From: Laura Gibbons
Sent: 02 April 2019 13:30
To: Planning.Responses
Cc: Simon Davis
Subject: RE: Planning Consultation on: BR/49/19/OUT

Engineers Comments Regarding Surface Water Drainage

BR/49/19/OUT

Registered: 18th March
2019
Site Address: 26 Burnham Avenue Bognor Regis PO21 2JU
Grid Reference: 493076 99429
Description of Works: Outline application with all matters reserved for 22 No. new dwellings consisting of 2 No. 1 bed dwellings, 18 No. 2 bed dwellings & 2 No. 3 bed dwellings.

Roof / Site Plan (Proposed) 1:200

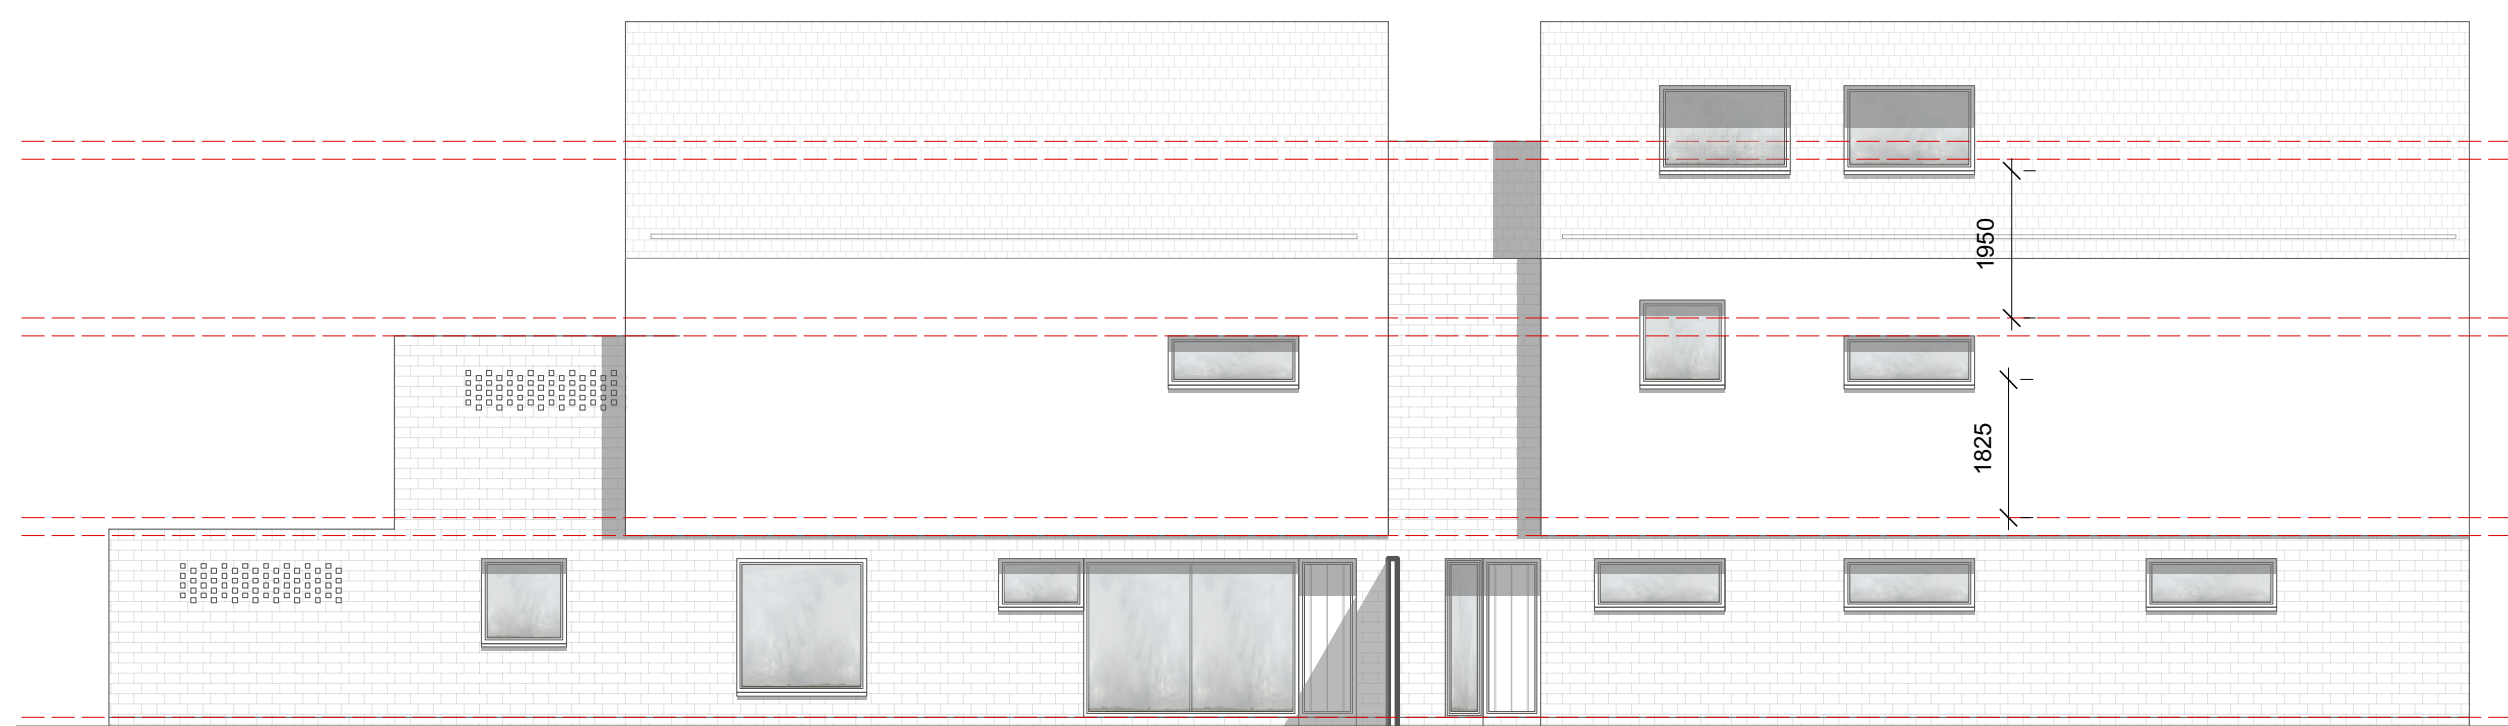
The plans provided leave little space for surface water drainage features. Infiltration must be fully investigated, a minimum of 5m must be provided from buildings to soakaways. Overdevelopment would not be justification for not using infiltration.

"Development shall not commence, other than works of site survey and investigation, until full details of the proposed surface water drainage scheme have been submitted to and approved in writing by the Local Planning Authority. The design should follow the hierarchy of preference for different types of surface water drainage disposal systems as set out in Approved Document H of the Building Regulations, and the recommendations of the SuDS Manual produced by CIRIA. Winter groundwater monitoring to establish highest annual ground water levels and winter Percolation testing to BRE 365, or similar approved, will be required to support the design of any infiltration drainage. No building / No part of the extended building shall be occupied until the complete surface water drainage system serving the property has been implemented in accordance with the agreed details and the details so agreed shall be maintained in good working order in perpetuity."
